Subject: RE: Attached letter from Kirklees Council regarding application number 2023/93464 at location Land at, Lingards Road, Slaithwaite, Huddersfield, HD7 5HY

I would like to advise that conditions 13 (Highway retaining walls), 14 (Highway embankments), 15 (Stability Remediation Strategy) and 16 (Drainage infrastructure in highway) can not be discharged for the following reasons:

BASE REINFORCEMENT DETAILS

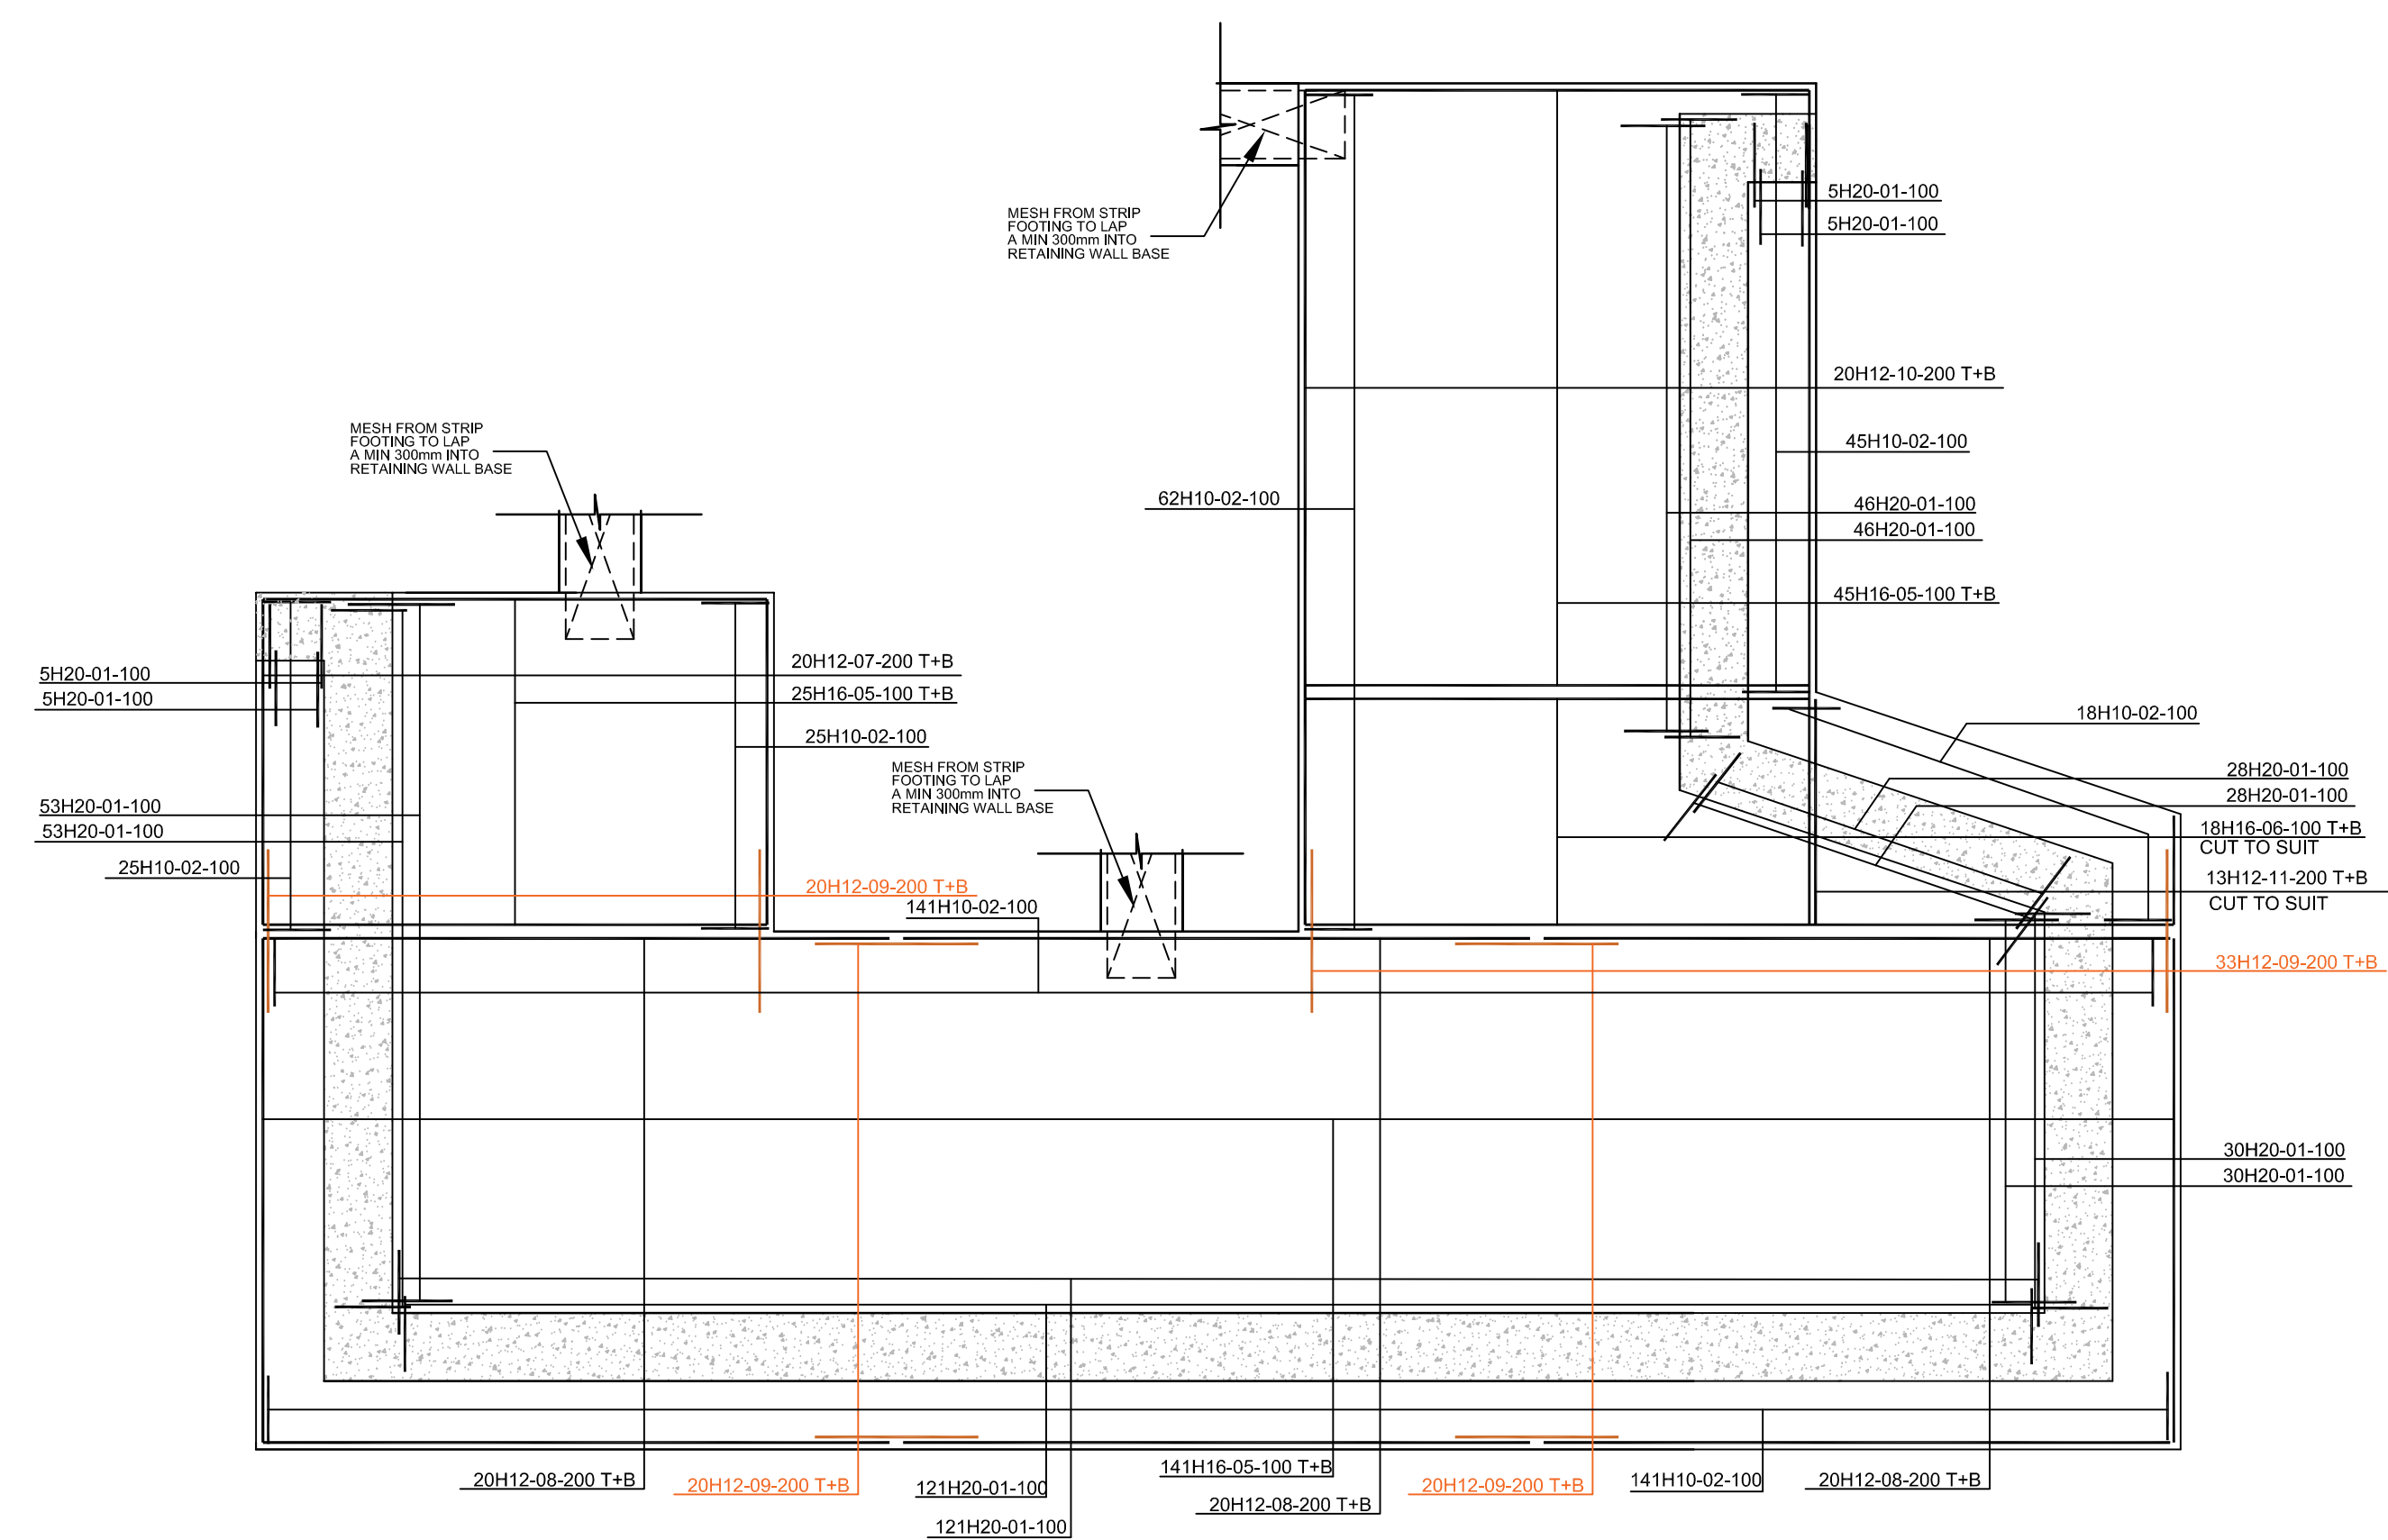
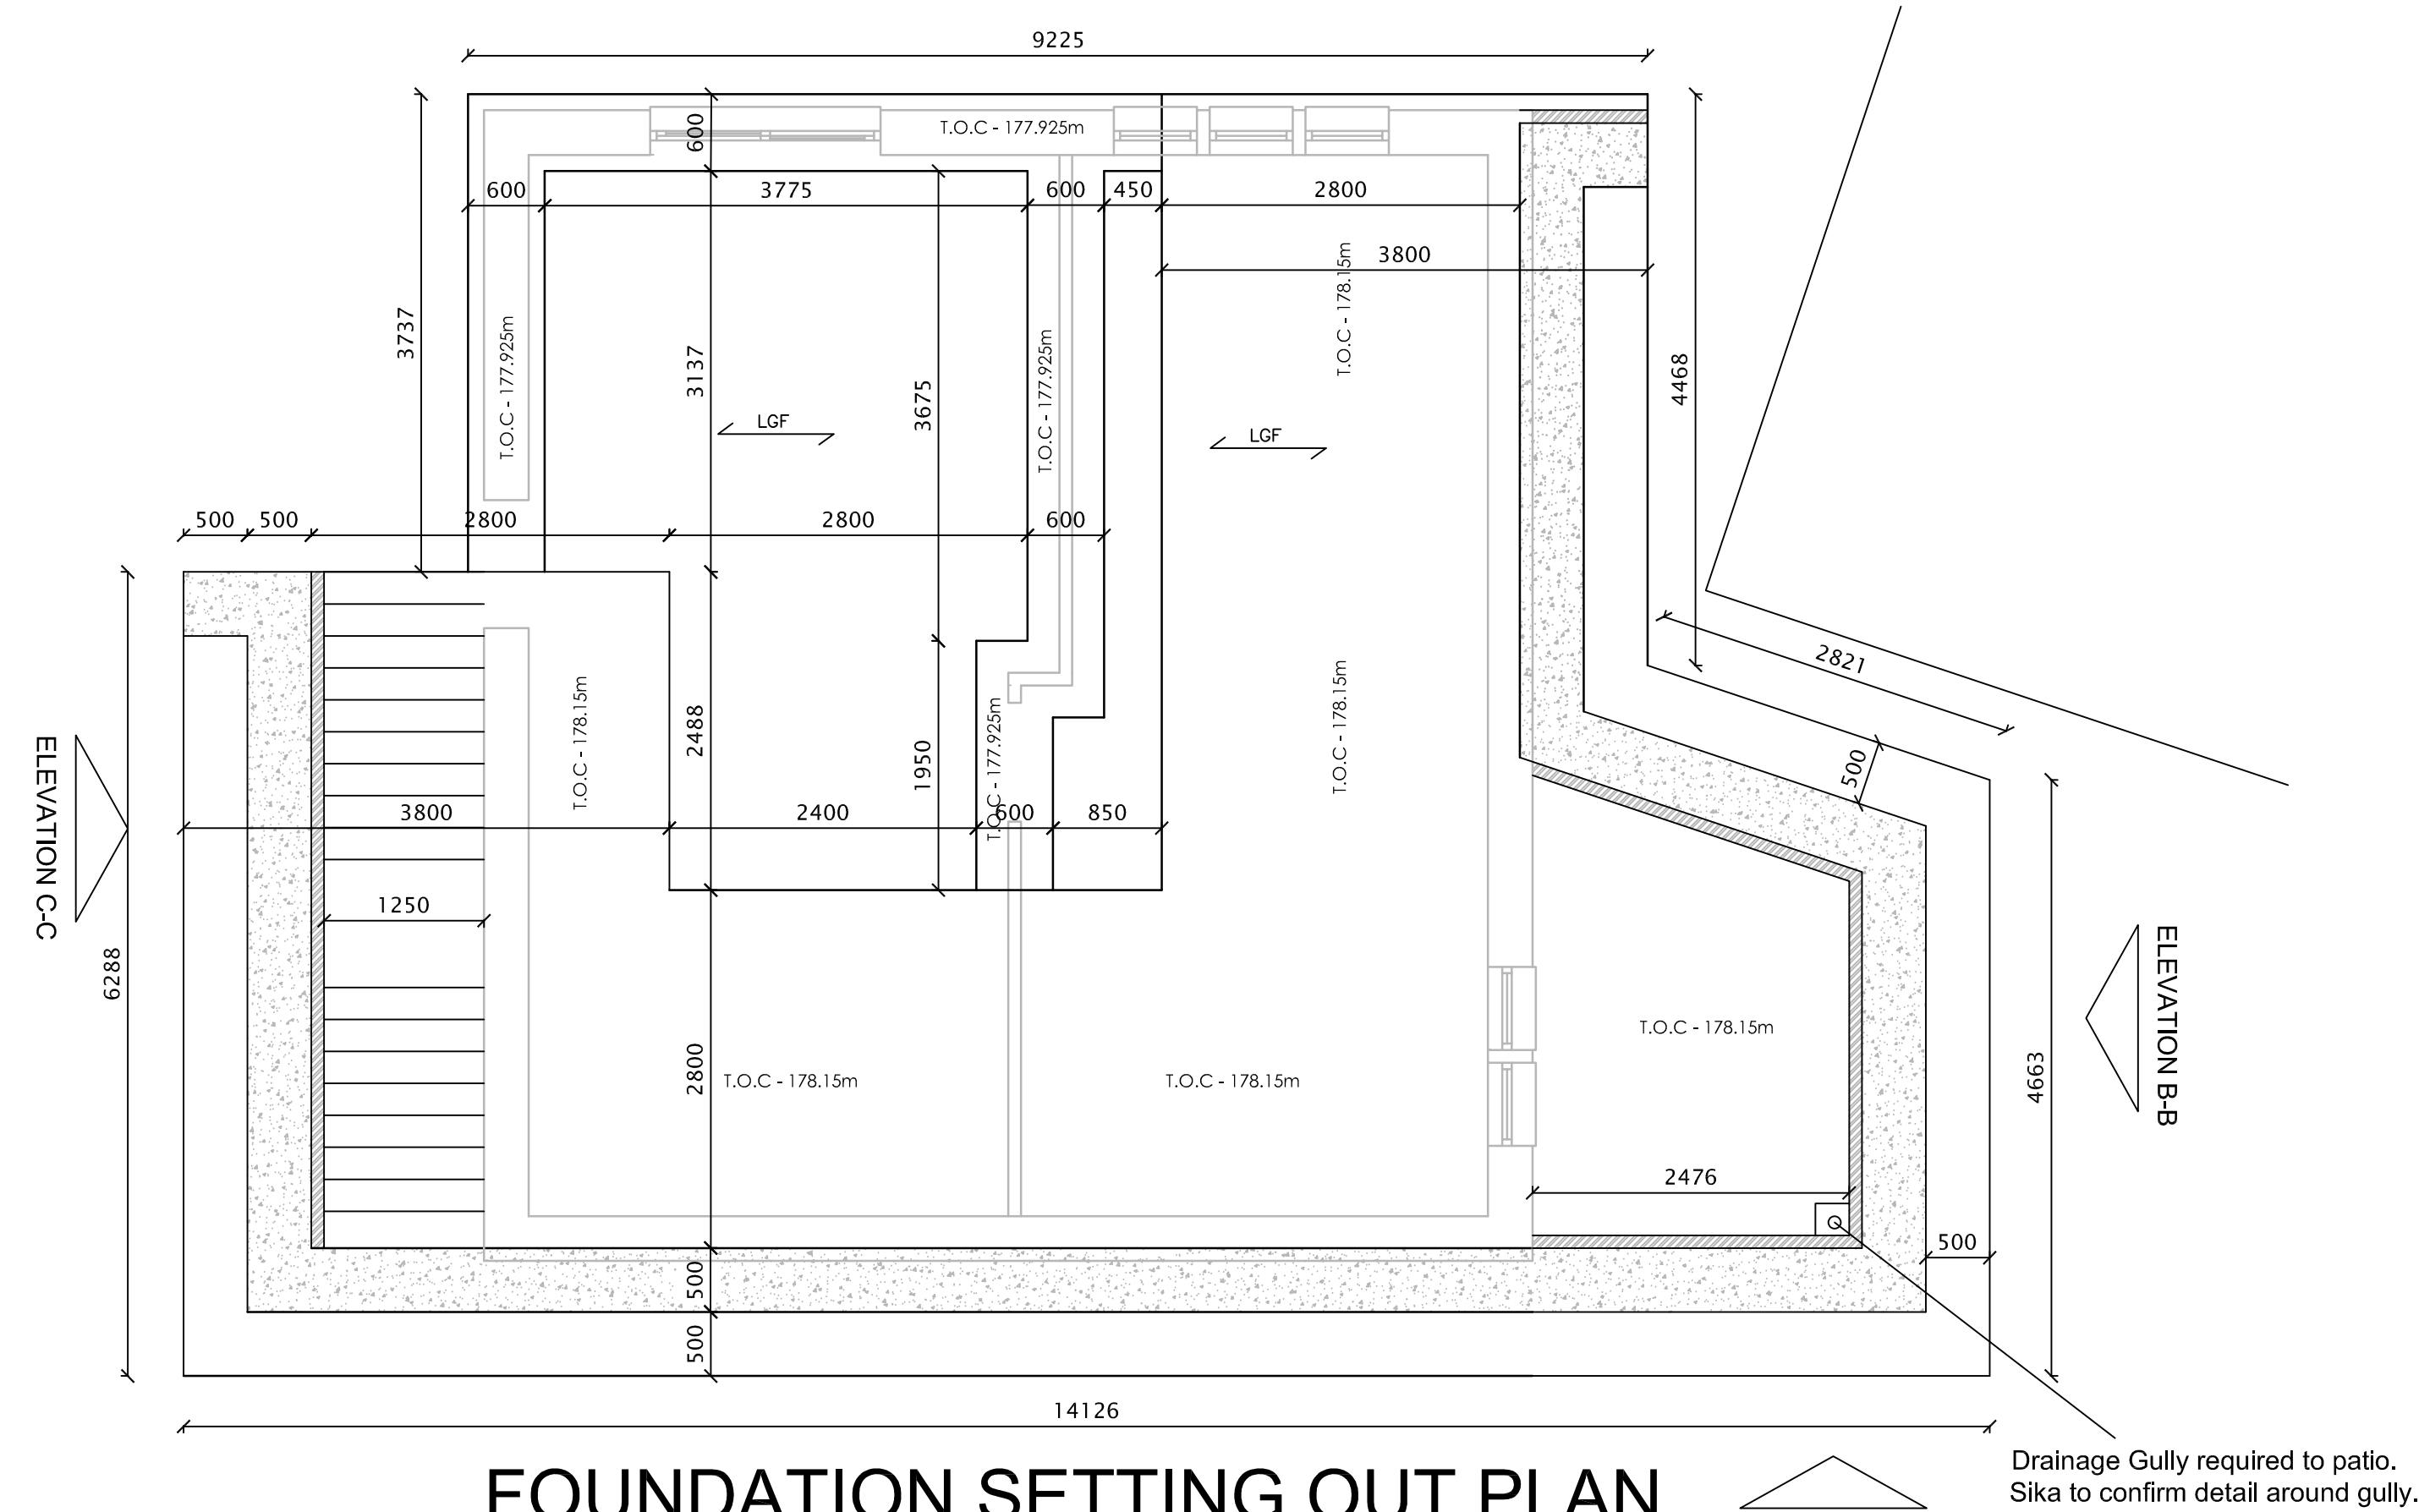
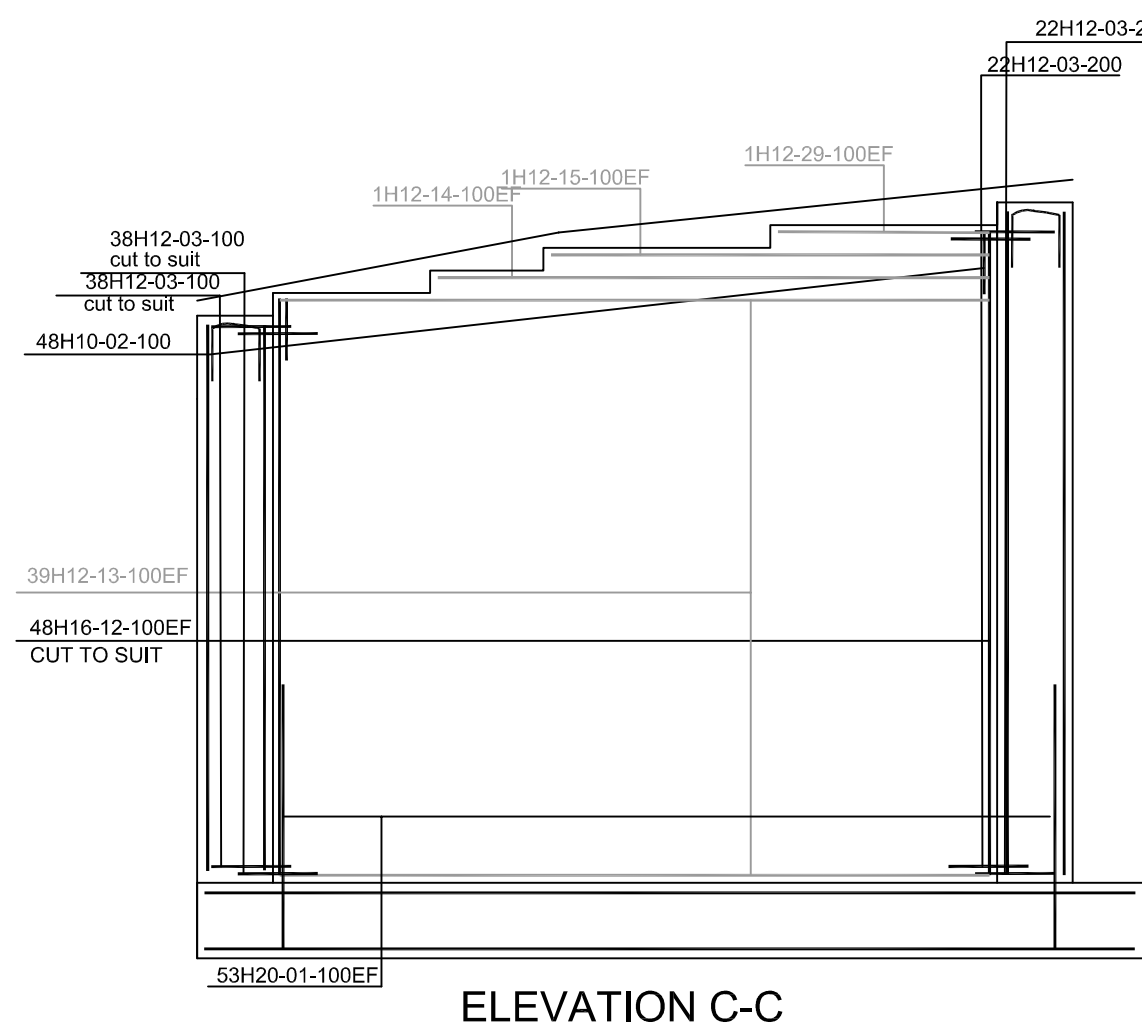
- 1) The discharge of condition 13 is interlinked with the satisfactory outcome of conditions 14 & 15 and also strictly subject to the successful completion of technical approval process (via submission of AIPs) for the design of proposed burr walls supporting the highway adj to Road 1, Road 2 and plots 13/14 together with any other retaining walls adjacent to the highway, which may be liable to a formal technical approval at this site.
